19 February 2018

Reference: A/18/8/PL for Application for Variation of Condition 2 imposed under A/173/16/PL to read "the development to be carried out in accordance with the following approved plans ADC962/04 REVA, ADC962/13 & ADC962/14 relating to revised position of rooflights on east, north & south elevations. This application affects the Character & Appearance of the Angmering Conservation Area at Land Rear of 1 To 6 The Cottrells Angmering

Location: Land Rear of 1 to 6 The Cottrells, Angmering

A		Layout amended		10.11.17	
Rev		Description		Date	
Job Reference		Client			
New House The Cottrells Angmering, BN16 4AF		AM Homes Ltd			
Drawing Title		Drawing No		Rev	
Ground Floor Plan		ADC962/04		A	
Date	Scale	Dwg Size	Plot Style	Drawn	Checked
24.04.17	1:100	A3	ADC-red	TGS	AD

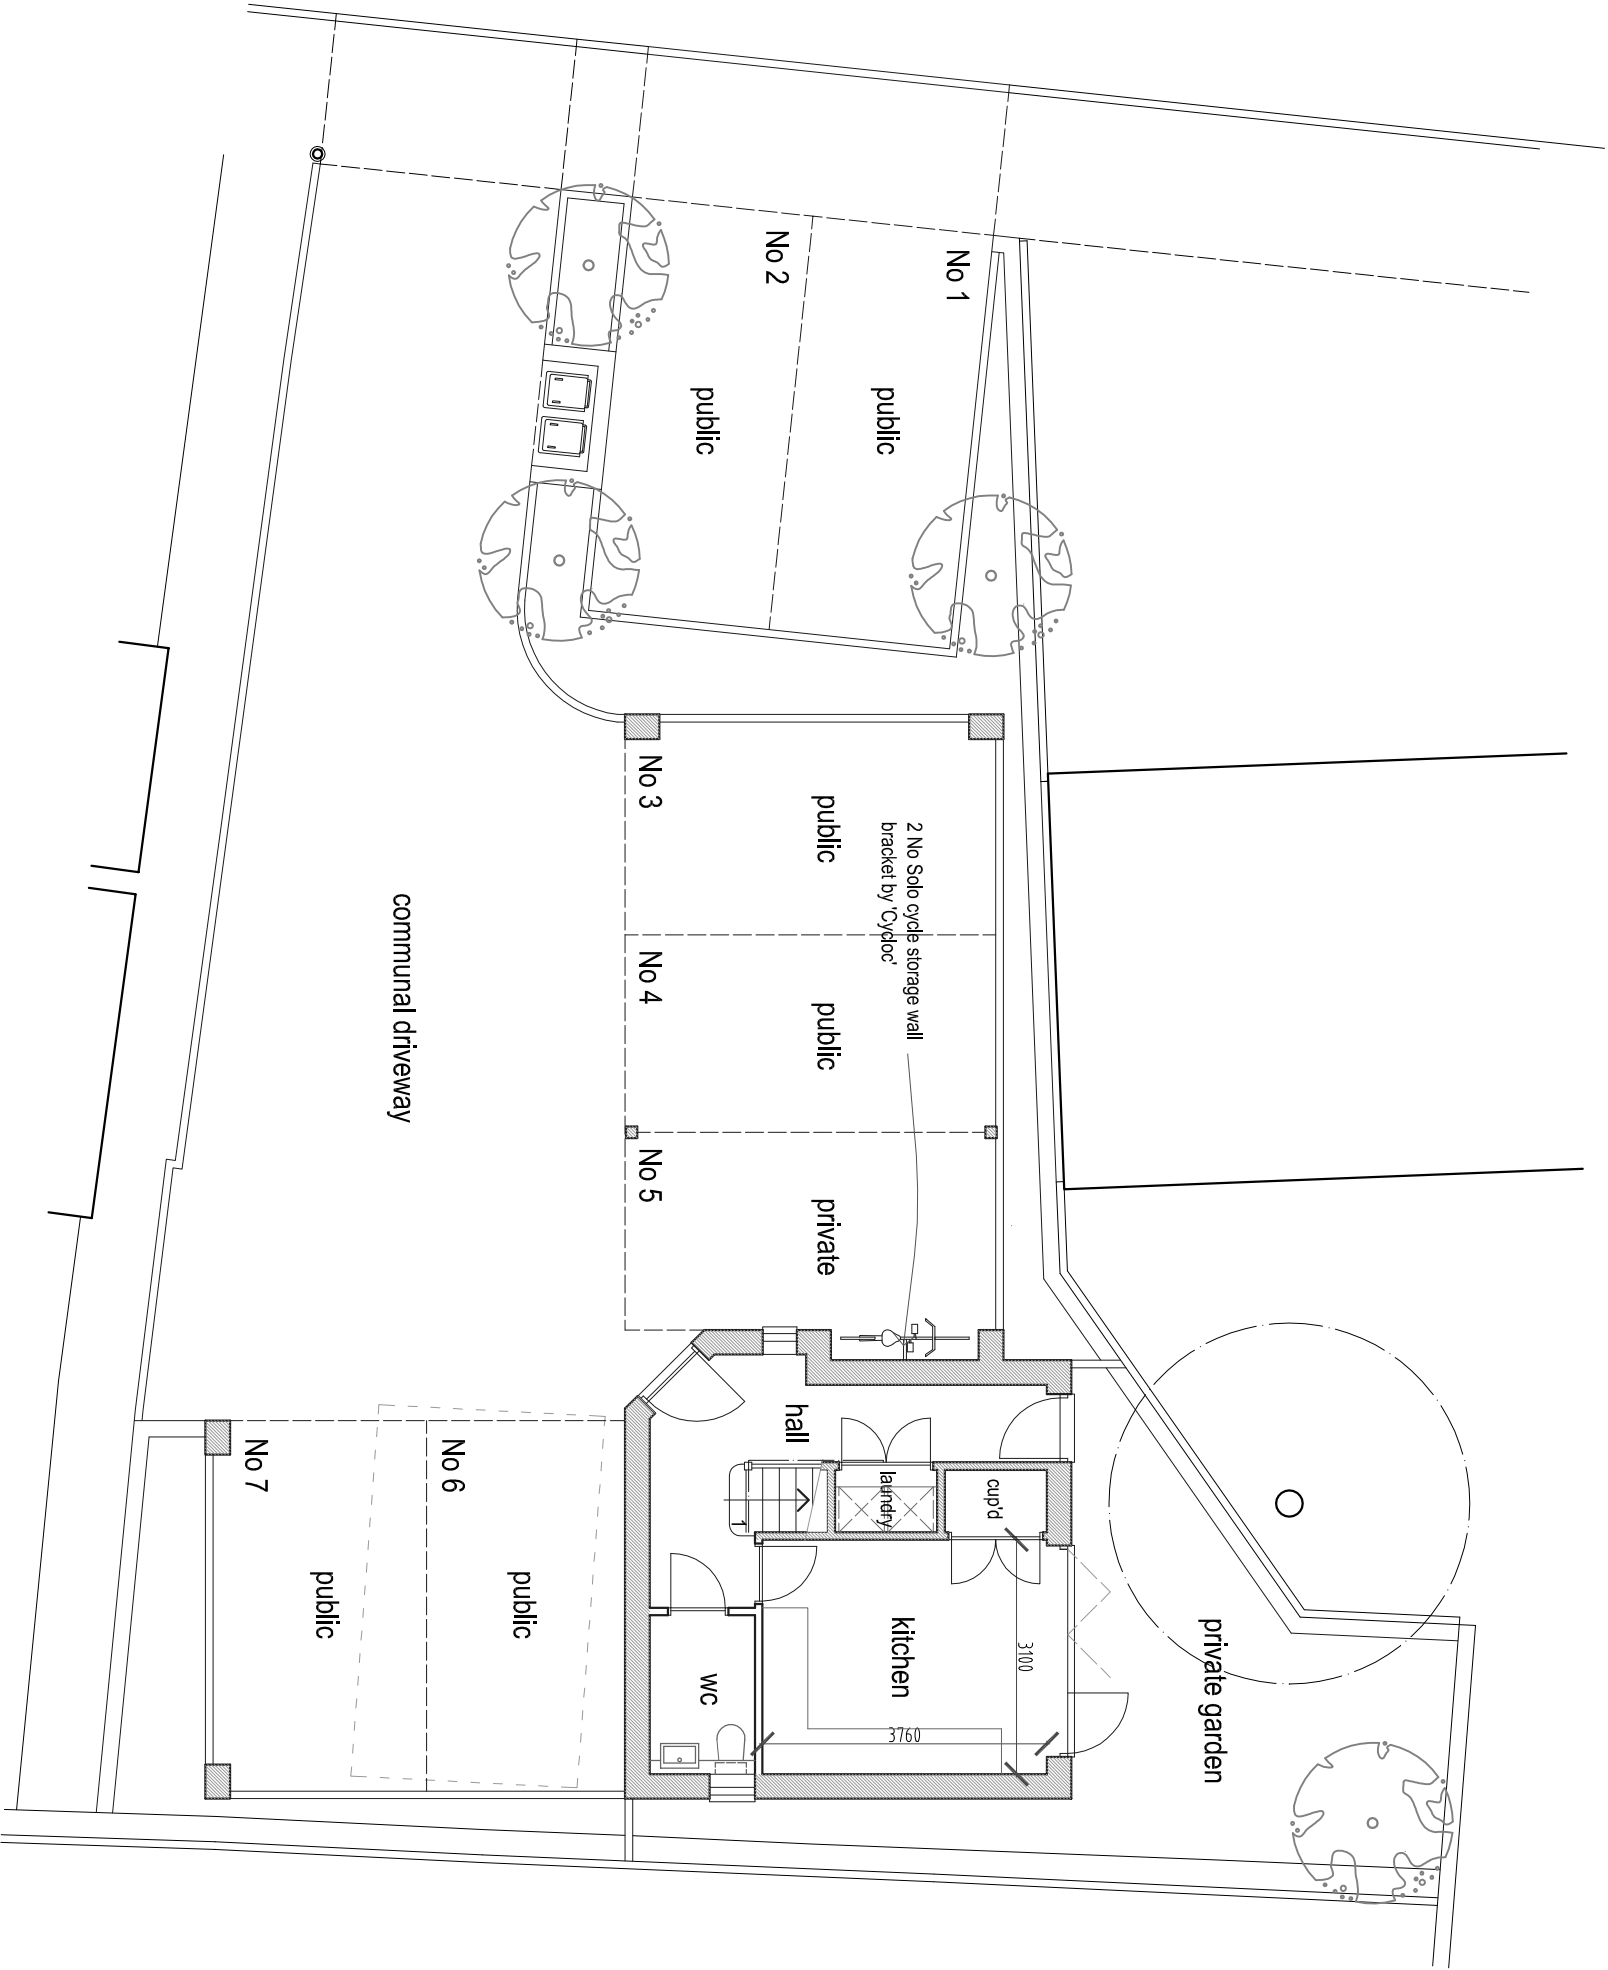
I am believe that the wall adjoining my property (on the south side of public parking space labelled 7 on the plans) has been built larger than on the submitted plans, at the wrong angle and is contravening building regulations by obstructing access to man hole covers for drains that connect to properties 4,5 and 6 The Cottrells.

Although I am not a surveyor I have taken measurements from the submitted plans and compared them with measurements I have taken from the site. I found the wall on site to be 5.45m whereas using a scale rule the

wall on the plans show it at 5m. I therefore question if the building has been positioned differently to the positioning shown in the submitted plans. These may seem like small measurements but on a plot this size they are significant.

I request that all of the measurements on the plans are checked against the current construction before any decisions are made on the current application and the wall rebuilt so as to not obstruct the drain covers. I also request that the angle of the wall is checked.

The internal reconfiguration allows for the potential rearrangement of the rooms to increase the overall accommodation in the dwelling. The creation of a downstairs corridor and stairs external to the kitchen facilitates moving the kitchen upstairs and creating a third bedroom downstairs. I believe that it has already been confirmed with Building Compliance that the plumbing has been installed upstairs for the kitchen.

The plans also deviate from the approved plans by showing red brick and not timber posts. These are currently industrial style steels so:

Rev	Description	Date
Job Reference New House The Cottrells Angmering, BN16 4AF		
Client AM Homes Ltd		
Drawing Title First Floor Plan & Roof Plan		Drawing No ADC962/13
Date 16.01.18	Scale 1:100	Dwg Size A3
		Plot Style ADgrey.spl
		Drawn AD
		Checked AD

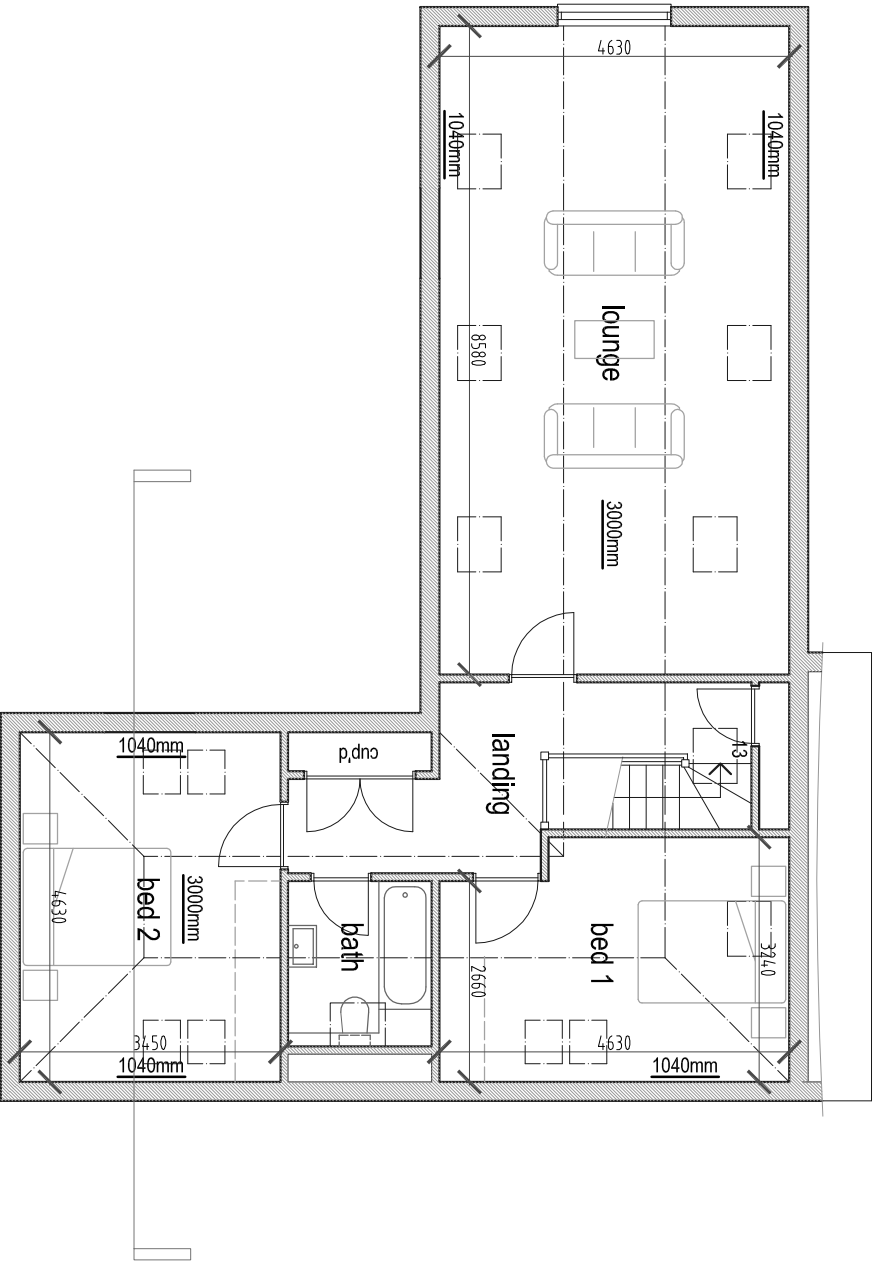
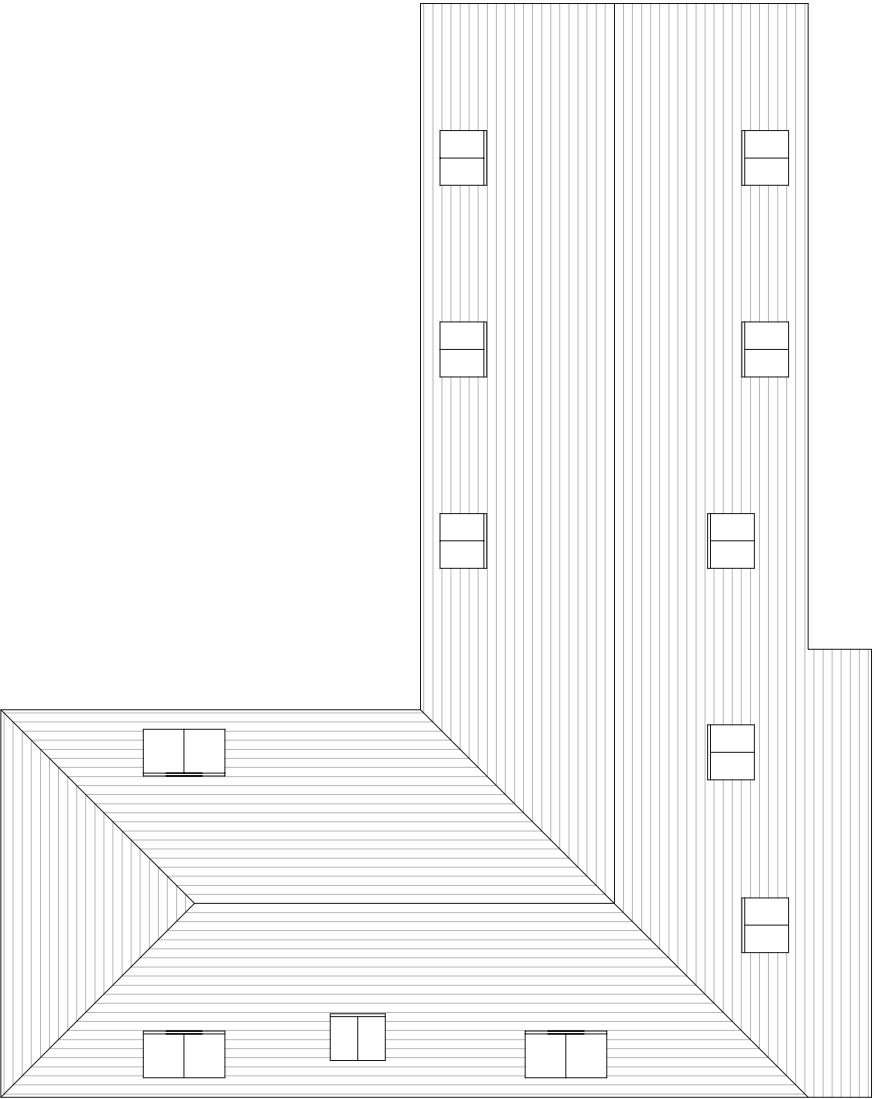
The elevations on this drawing are conflicting - they differ in their representations of the construction of the roof on the South Elevation. The West and East elevations on this drawing show a hip end on the roof that forms the south elevation as does ADC 962/13. The south elevation drawing however shows a barn end. The building that has currently been constructed shows a barn end so it can only be presumed that this is the developer's plan.

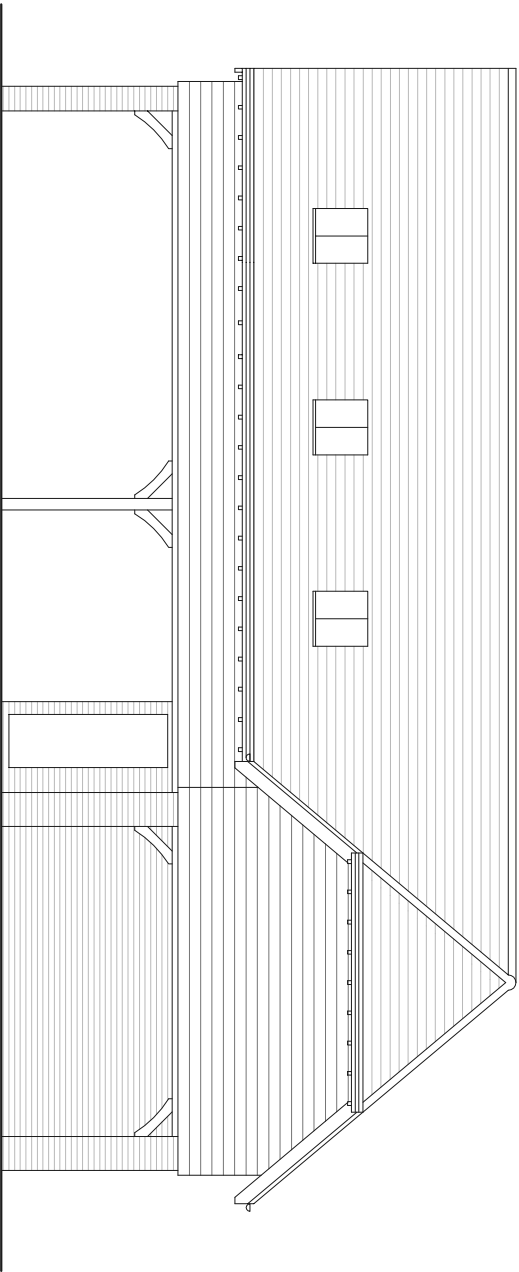
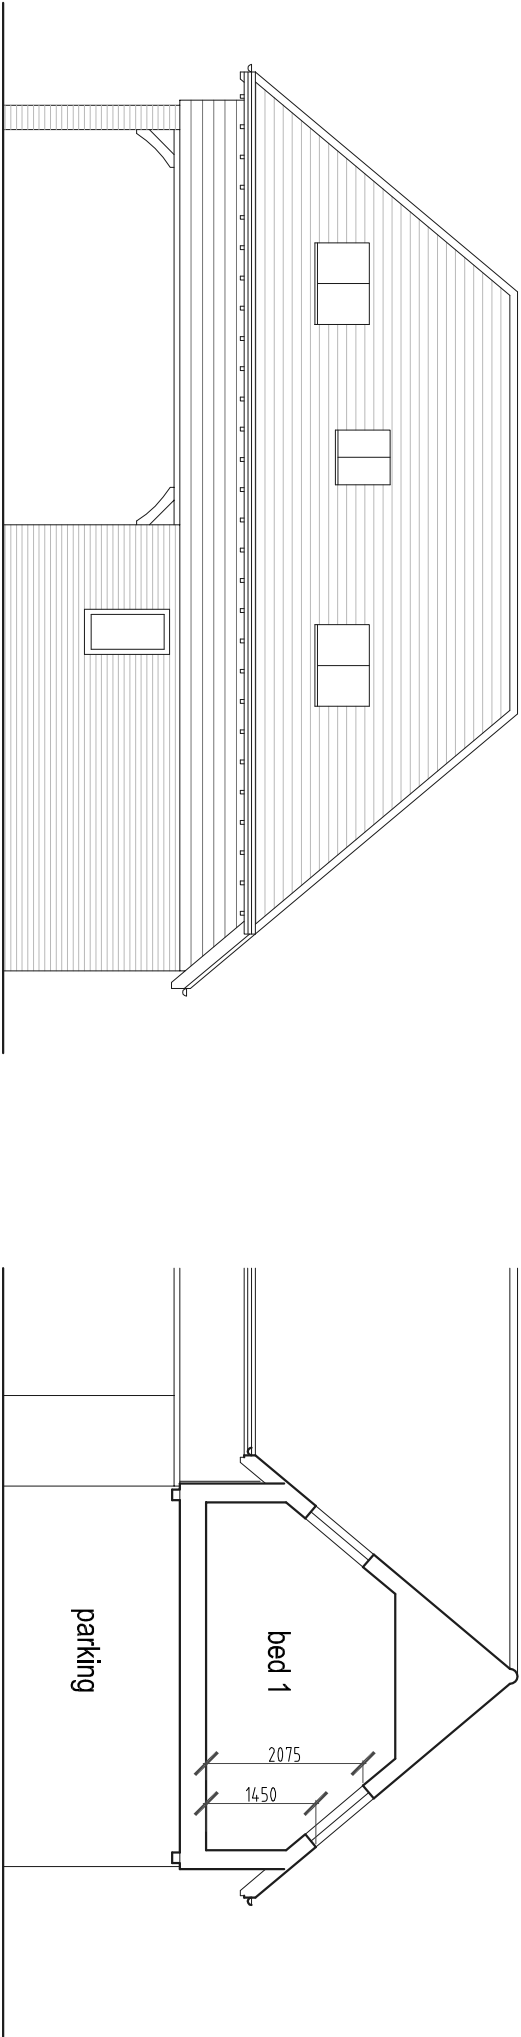
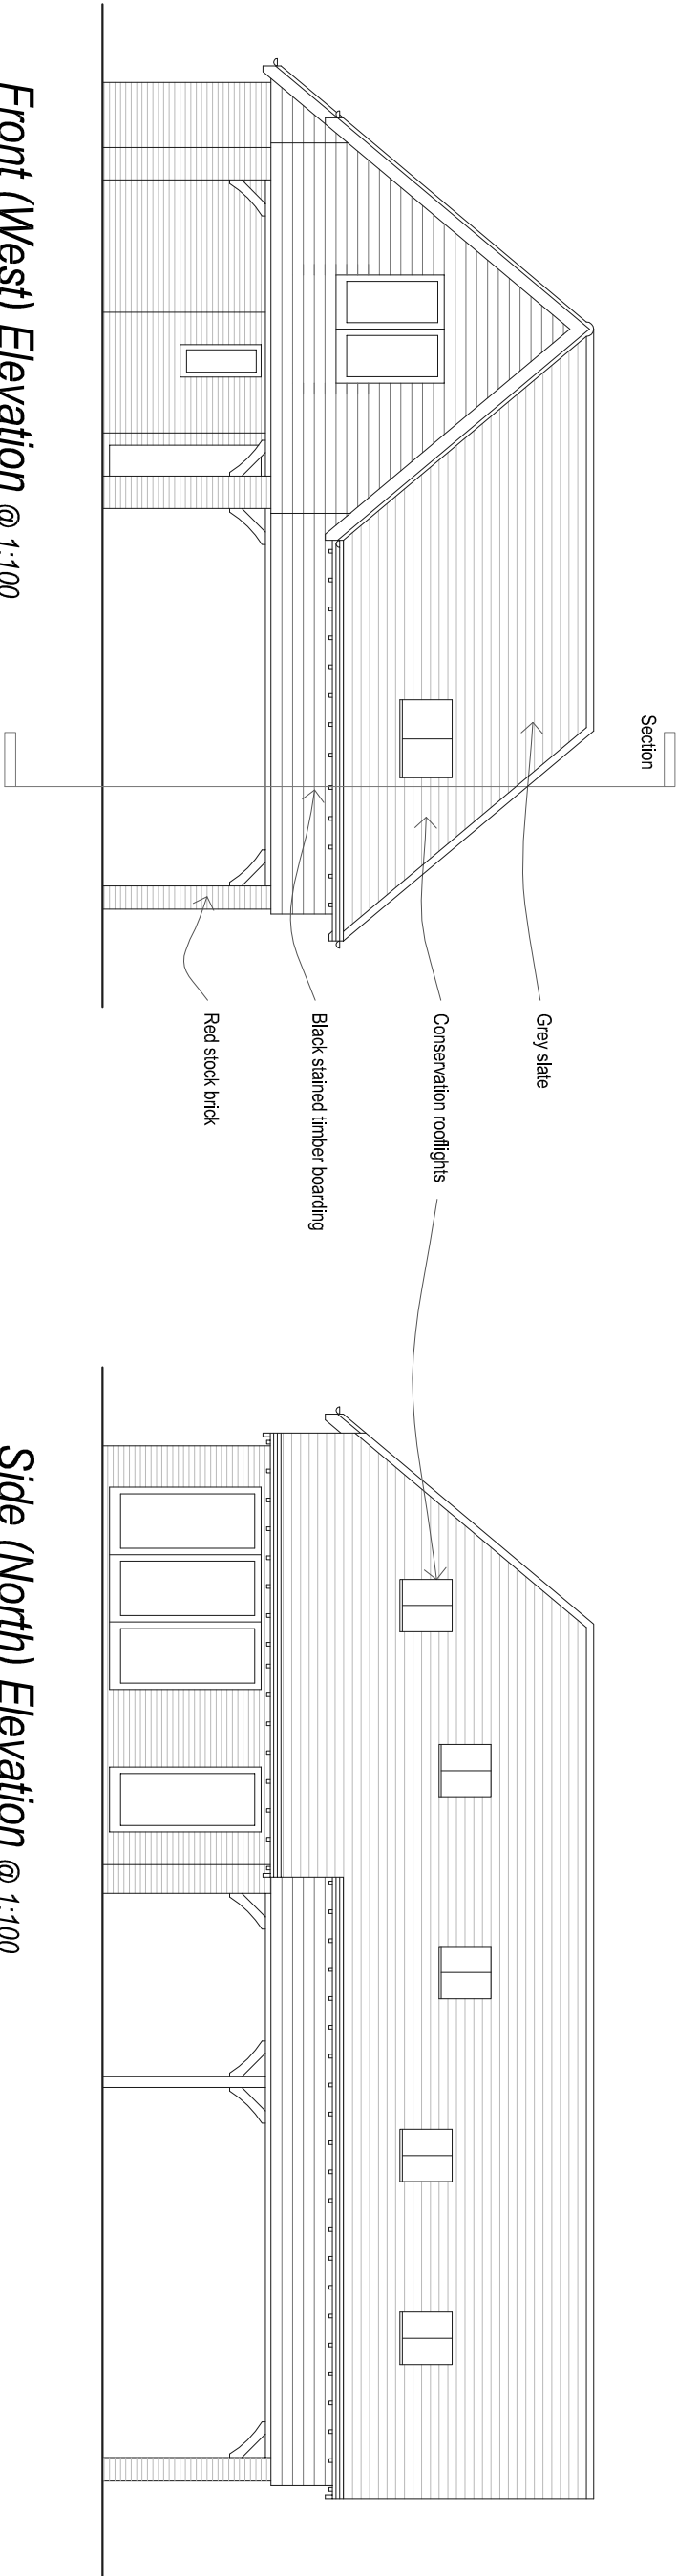
Ref: Drawing ADC962/14: Elevations and Sections:

The application wording is misleading, the wording references only the roof light locations whereas the drawings and current construction also show a major deviation from the approved plans.

I object strongly to the barn end. It is totally unacceptable, it has a dramatic and negative affect on mine and other properties. It is overbearing, out of keeping with its environment and is an attempt by the developer to build a bigger accommodation. I am beyond words as to how such a fundamental variation to the approved plans has taken place.

Although I am not an architect or surveyor, I do not believe that the currently constructed roof ridge and the current west elevation window position would allow for a hip to be constructed without the roof and guttering overhanging my property. To achieve the hip end I believe the roof ridge needs to be reduced.

I request that the roof is taken back to the hip end the original approved application (A/173/16/PL) and the positioning of the building to be considered so that there is no overhang over the site's boundaries and all future maintenance can be achieved from within the site itself.

The building has been fitted with windows not the approved escape roof lights. This gives the windows a more domineering appearance and is not in sympathy with the conservation area. The approved plans section illustration show the lowest point of the windows to be 1.5m from the internal floor, the submitted plans drop them to 1.45m from the internal floor. This means that we can see directly into the property, indeed I have spoken to the builders working in one of the windows from my upstairs window. Clearly when the property is occupied this would compromise the surrounding properties' privacy. All along we have been told that the occupiers will not be able to look out of these windows, clearly this is not the case at all.
